**Draft Development Consent Order Hearing 1 Session 1
Transfer of Assets (43.30 in the transcript)**

Norfolk County Council
Identification No: TR010038
Registration identification number: 20028389

**NOTES**

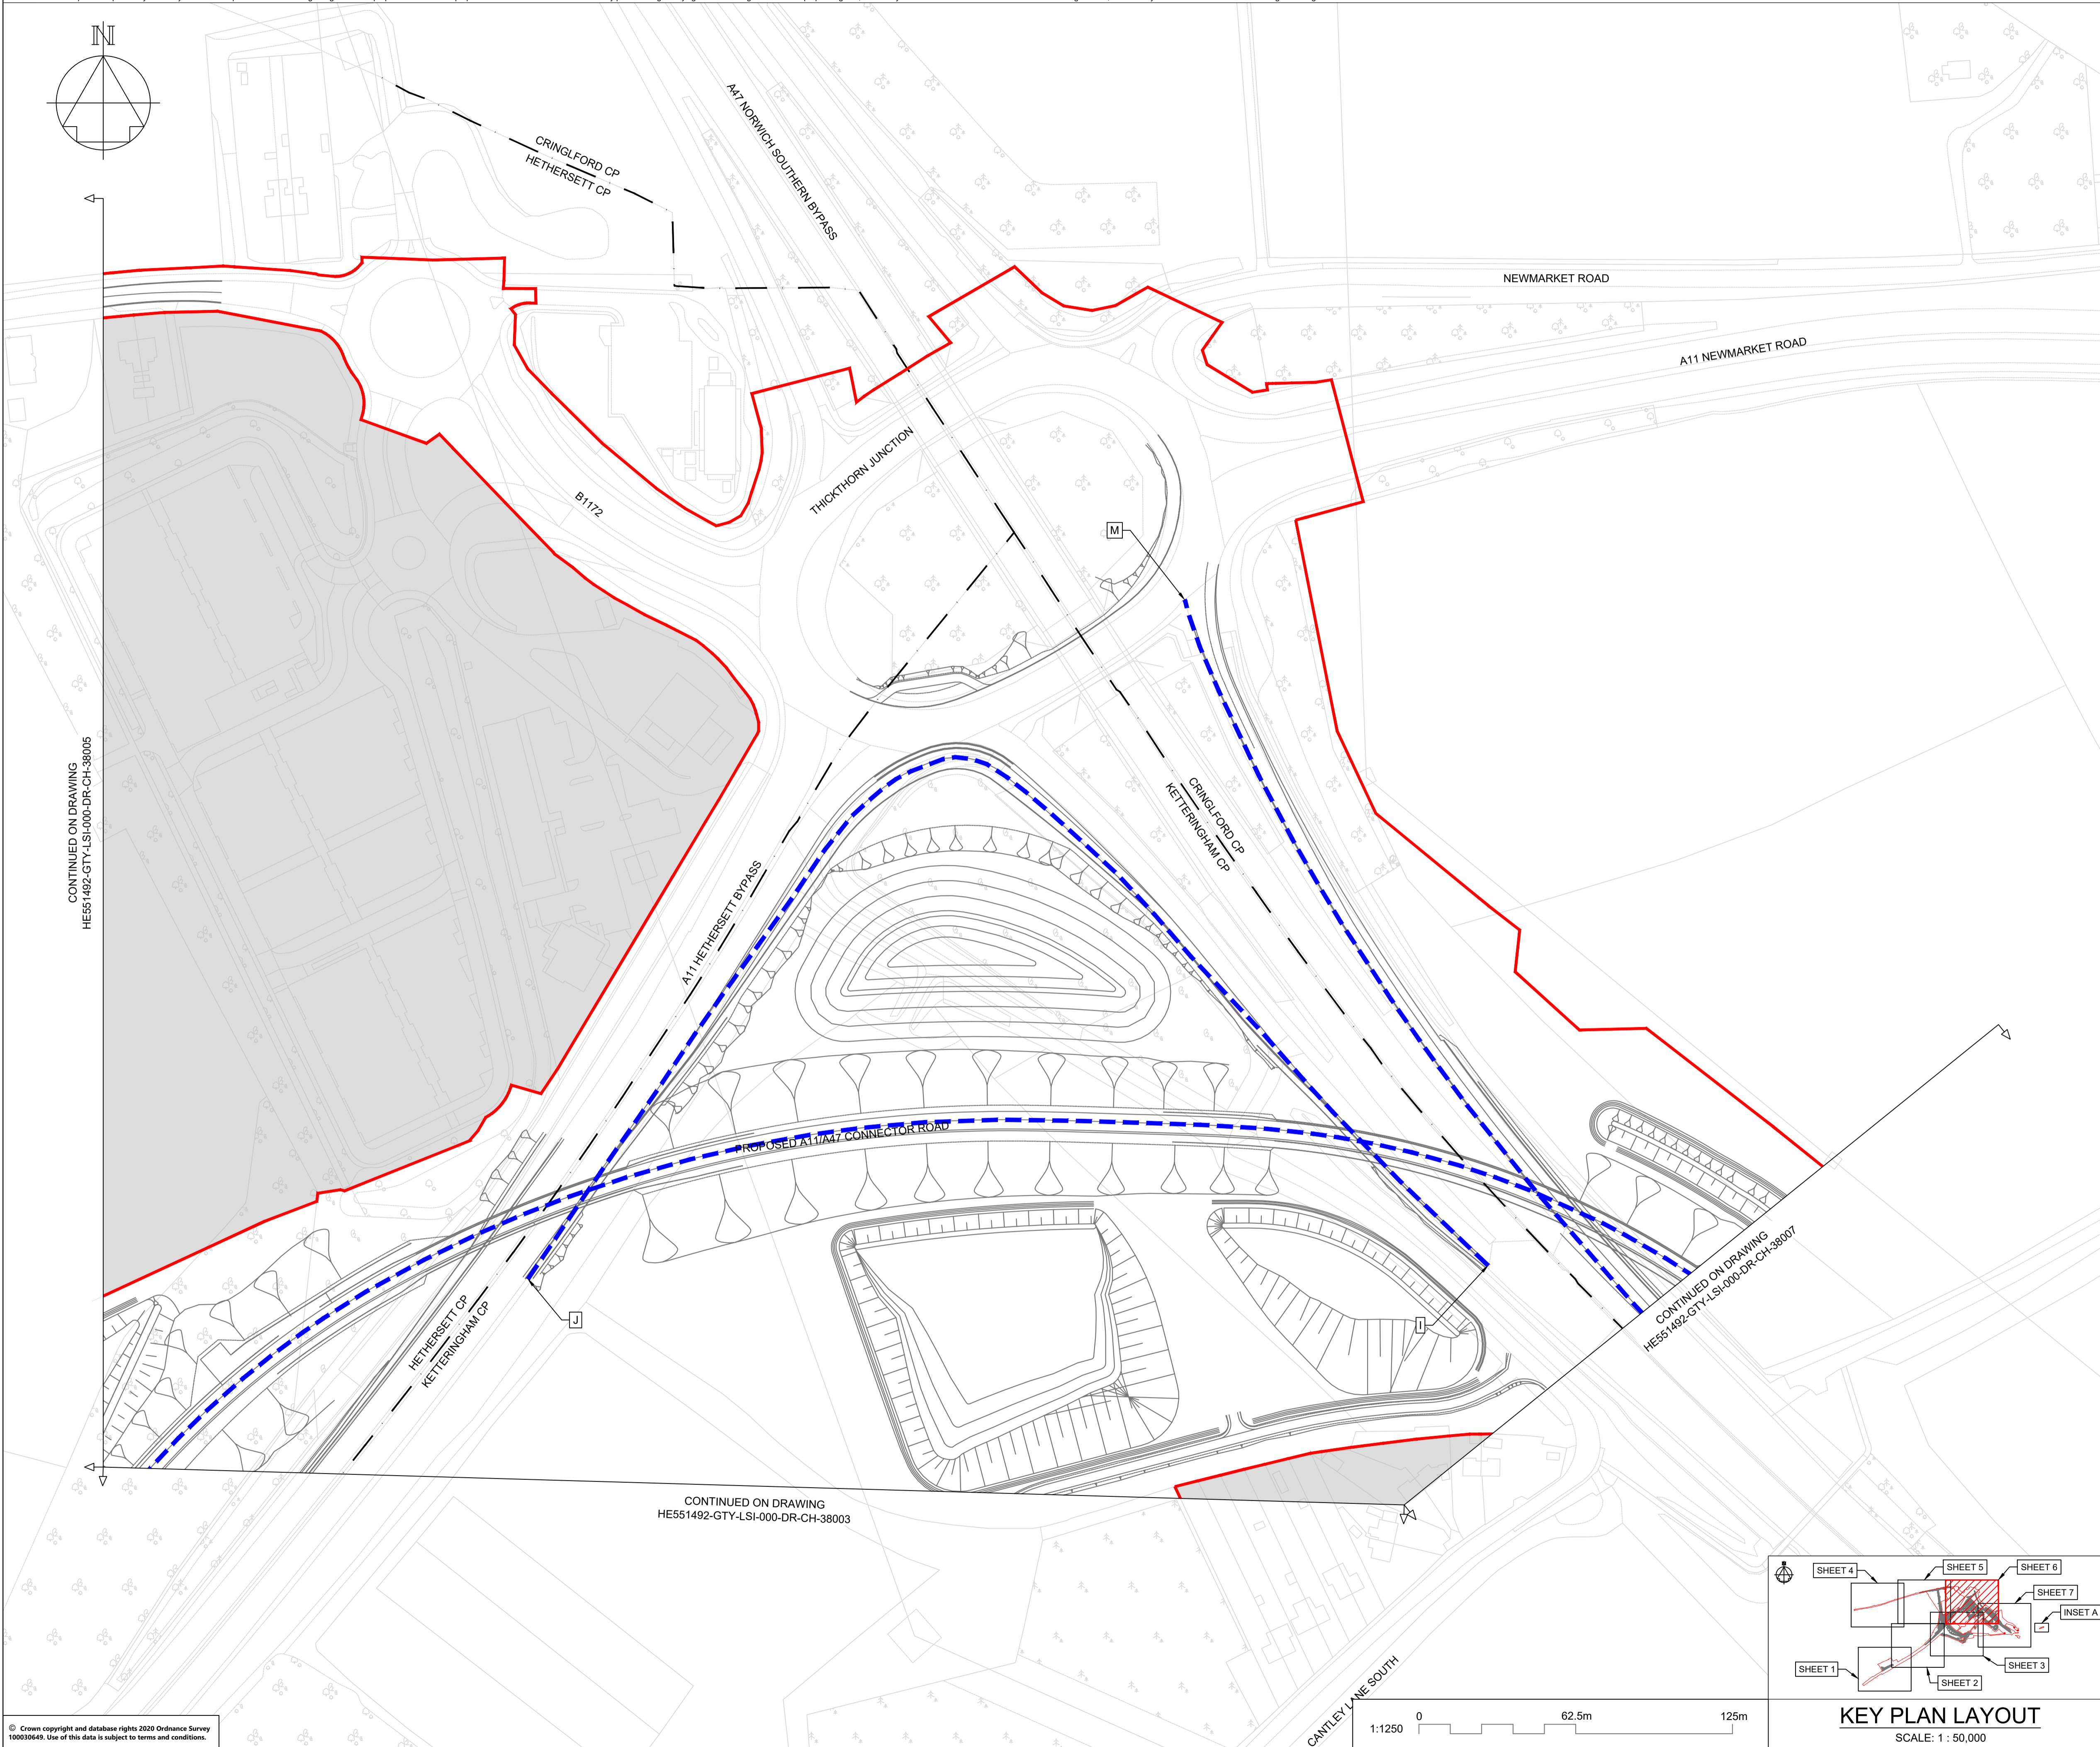
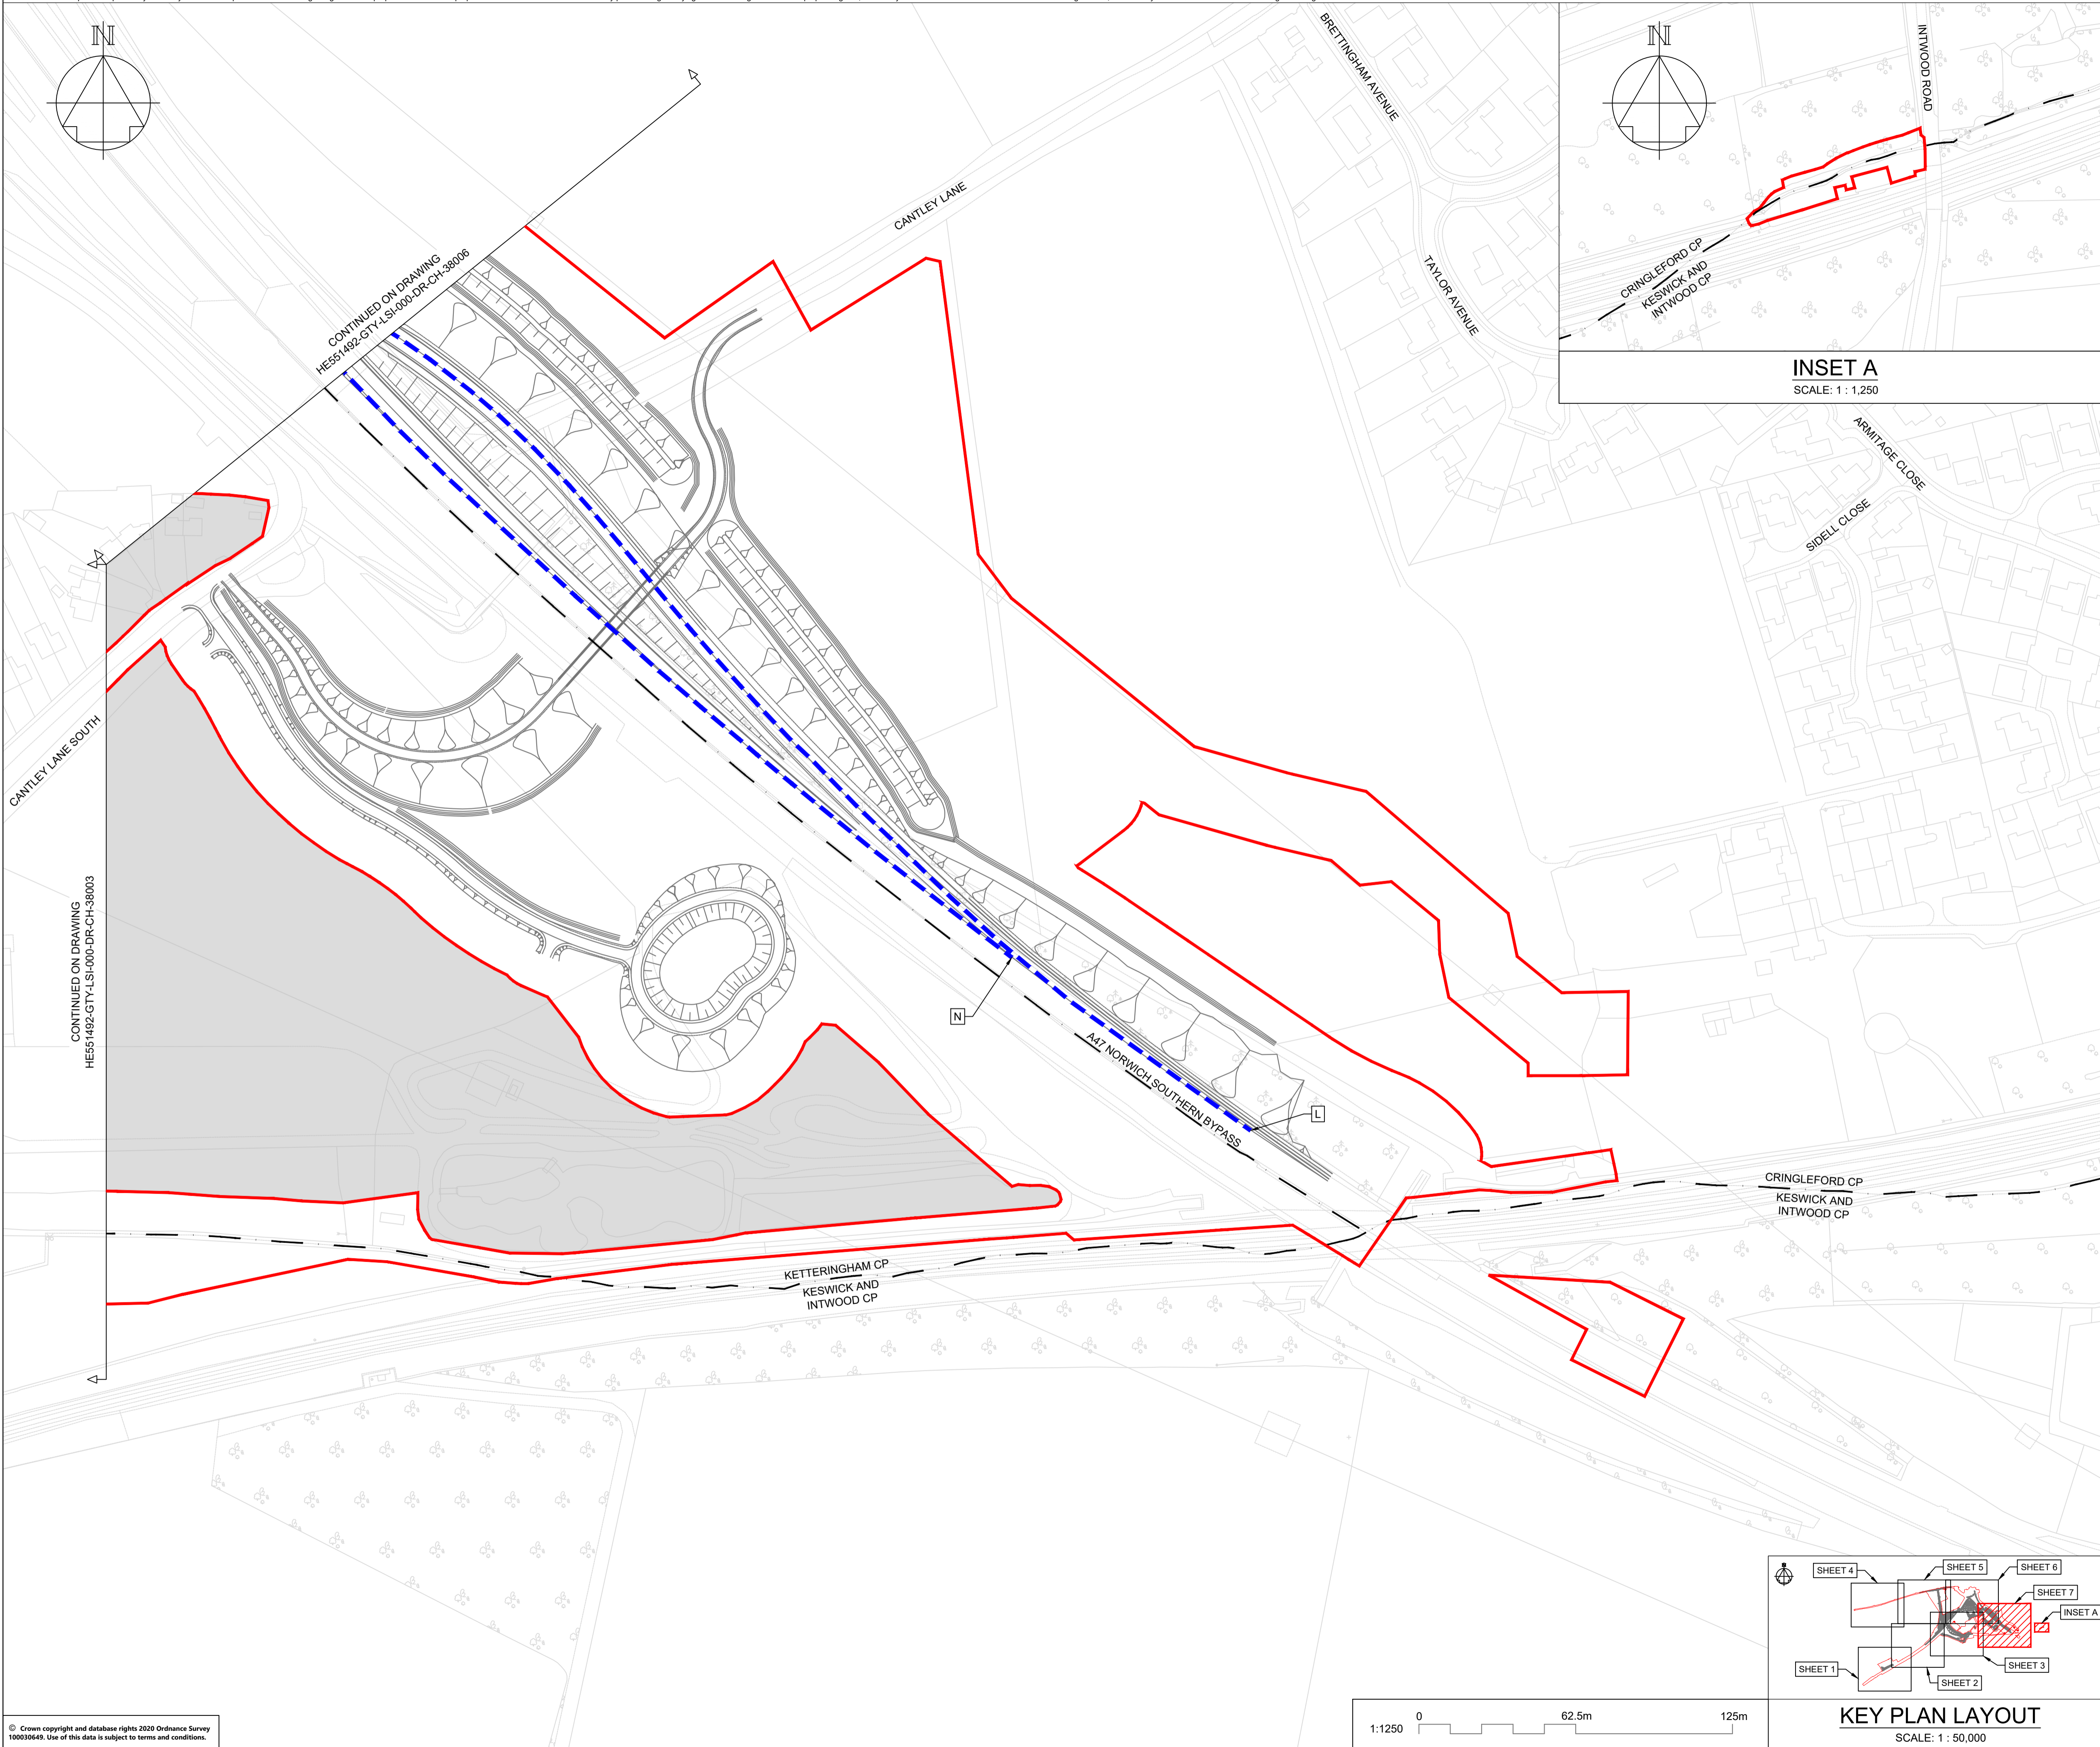
On the proposed classification of the new link from Cantley Lane to the B1172 as a Class B road (1.01.12 in the transcript)

The A11 and the A47 are the main roads within the area, and much of the rest of the network comprises minor roads. We have had concern expressed to us by some of the local residents and their representatives (parish councils) that the new link road would draw traffic from the south east up through Cantley Lane and the new link road, although we don't expect that to be a significant impact of the scheme.

However, the classification of the new link road as a B road would indicate to motorists, and also to things like Sat Nav systems, that it is part of a more major road network and could lead to its use by additional traffic.

The county council does not support classification of the new link road as a B class road.

The county council welcomes the applicant's statement (in the Hearings) that it will be led by the county council in respect of the classification of the new link road. This will be reflected in the Statement of Common Ground.
